April 24, 2017

Re: Ware House
1301 Cuesta Abajo Court, NE
Traffic Circulation Layout
Architect's Stamp 09-14-16 (D16D002H)

Based upon the information provided in your submittal received 4-11-17, the above referenced plan cannot be approved for Building Permit until the following comments are addressed:

12,000 SQ. FT. WAREHOUSE
1301 CUESTA ABAJO COURT, NE
ALBUQUERQUE, NEW MEXICO 87113
SHT. T-1

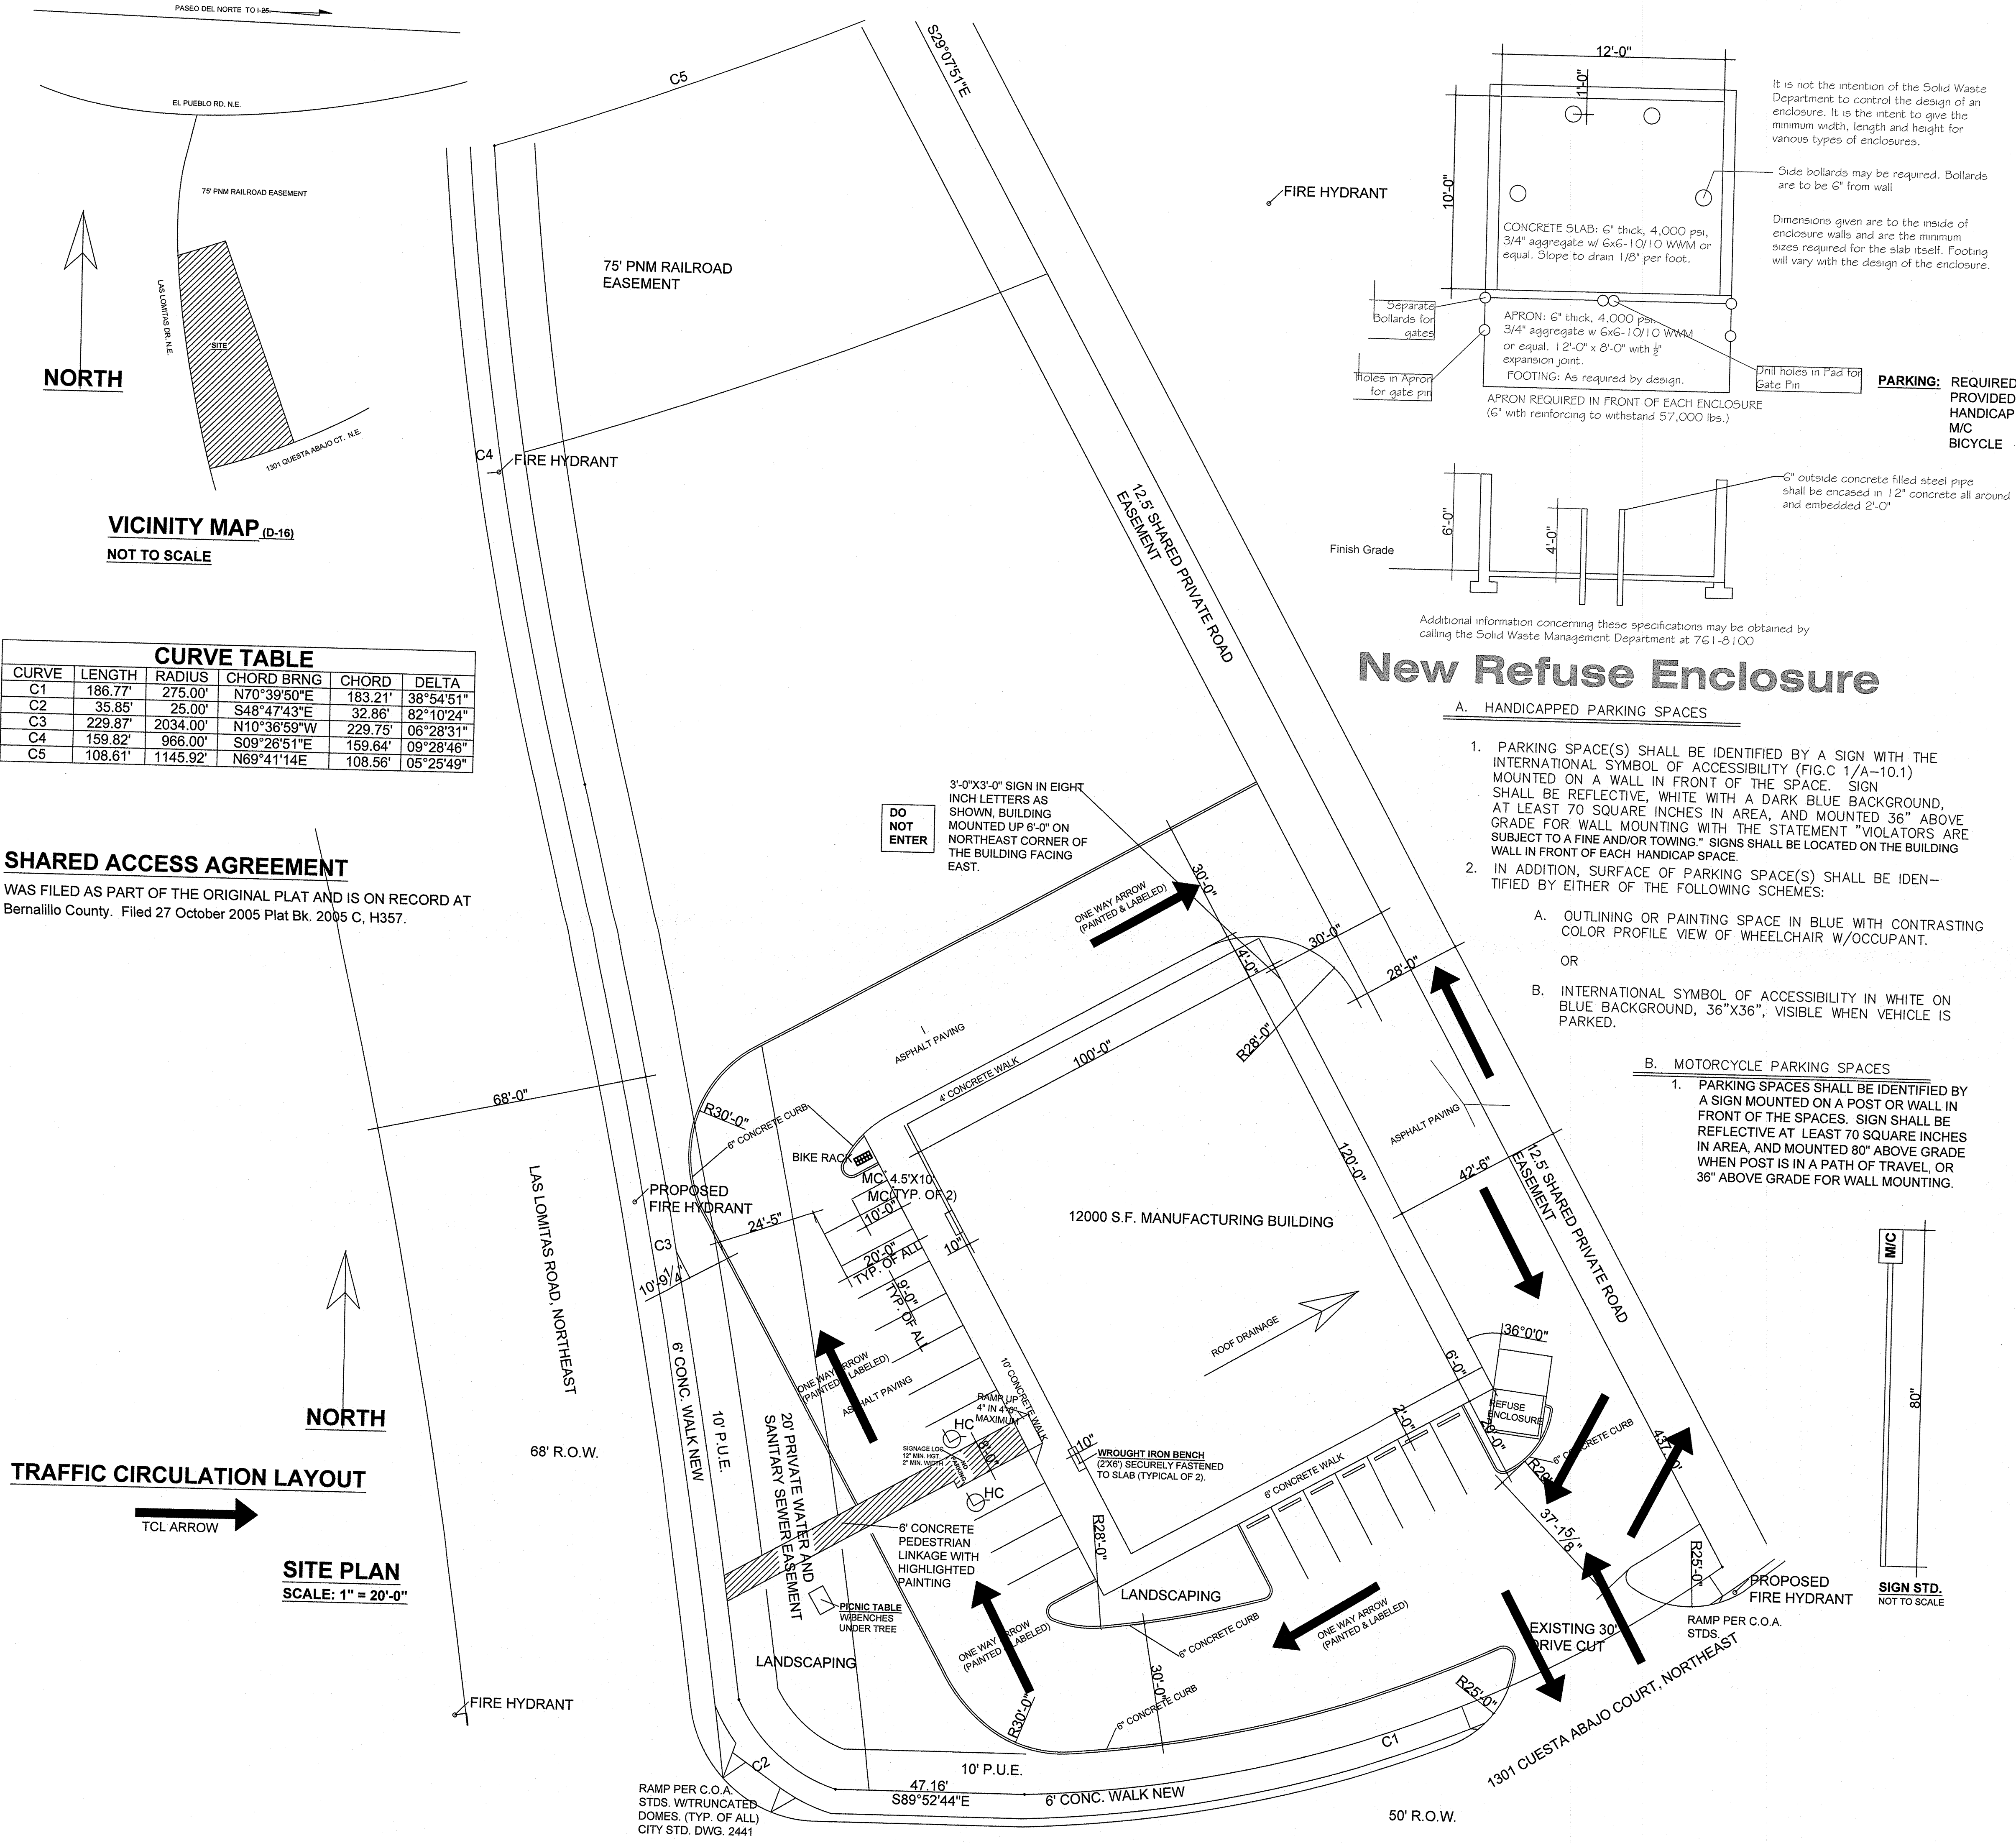
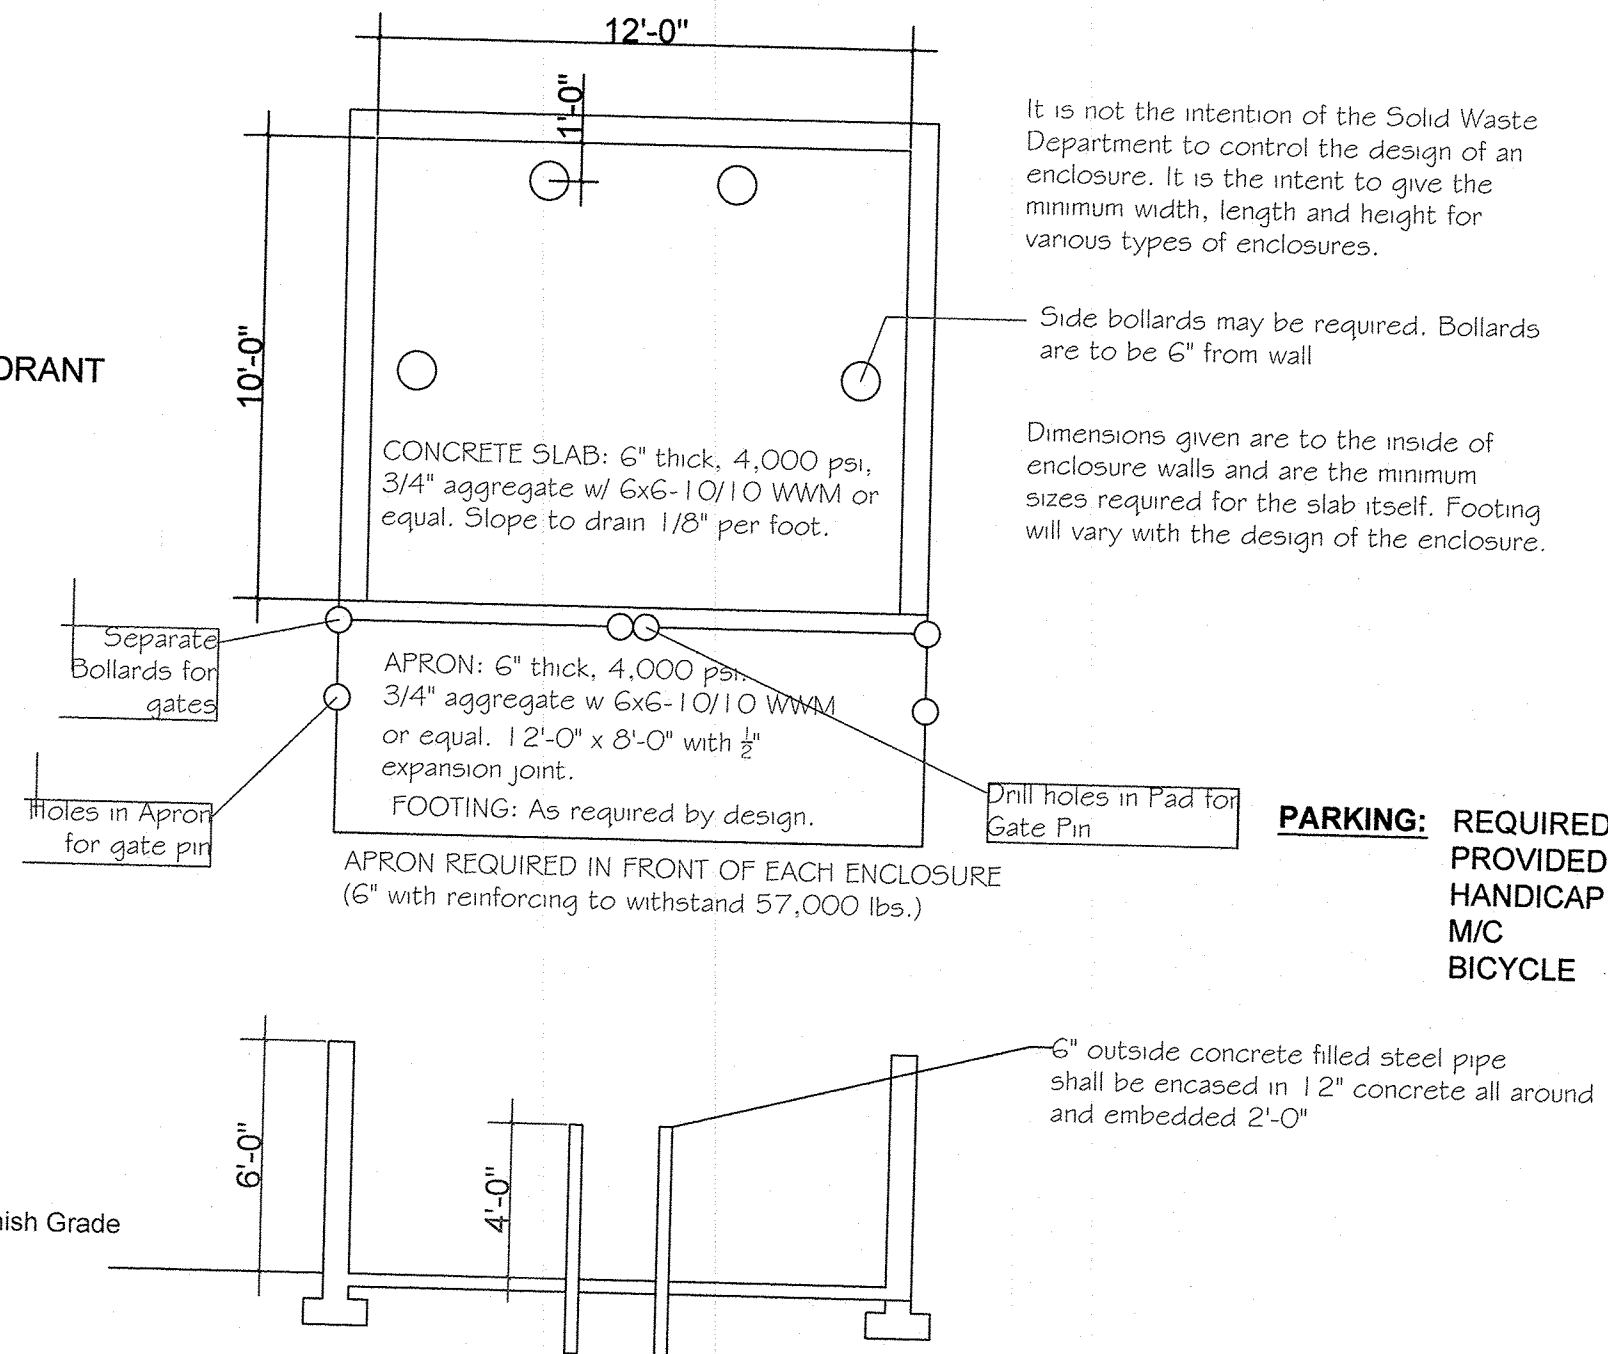
1. Please show a vicinity map showing the location of the development in relation to streets and well known landmarks.
2. List the number of parking spaces required by the zoning code as well as the proposed number of parking spaces including bicycle and motorcycle parking.

3. Please list the width and length for all existing and proposed parking spaces. Some dimensions are not shown.
4. The ADA access aisles shall have the words **"NO PARKING"** in capital letters, each of which shall be at least one foot high and at least two inches wide, placed at the rear of the parking space so as to be close to where an adjacent vehicle's rear tire would be placed. (66-1-4.1.B NMSA 1978)

5. Please include a copy of your shared access agreement with the adjacent property owner.
6. The ADA accessible parking sign must have the required language per 66-7-352.4C NMSA 1978 **"Violators Are Subject to a Fine and/or Towing."** Please call out detail and location of HC signs.

7. The handicap accessible spaces must include an access aisle. Van accessible aisles should be 8ft wide; all others should be 5ft wide.
8. One-way vehicular paths require pavement directional signage and a posted **"Do Not Enter"** sign at the point of egress. Please show detail and location of posted signs.

9. Please specify the City Standard Drawing Number when applicable. Label new sidewalk as new or proposed.

10. The ADA curb Ramp at the intersection of Cuesta Abajo Ct NE and Las Lomas Dr NE should be updated to current ADA standards. The ADA curb ramp should have truncated domes.
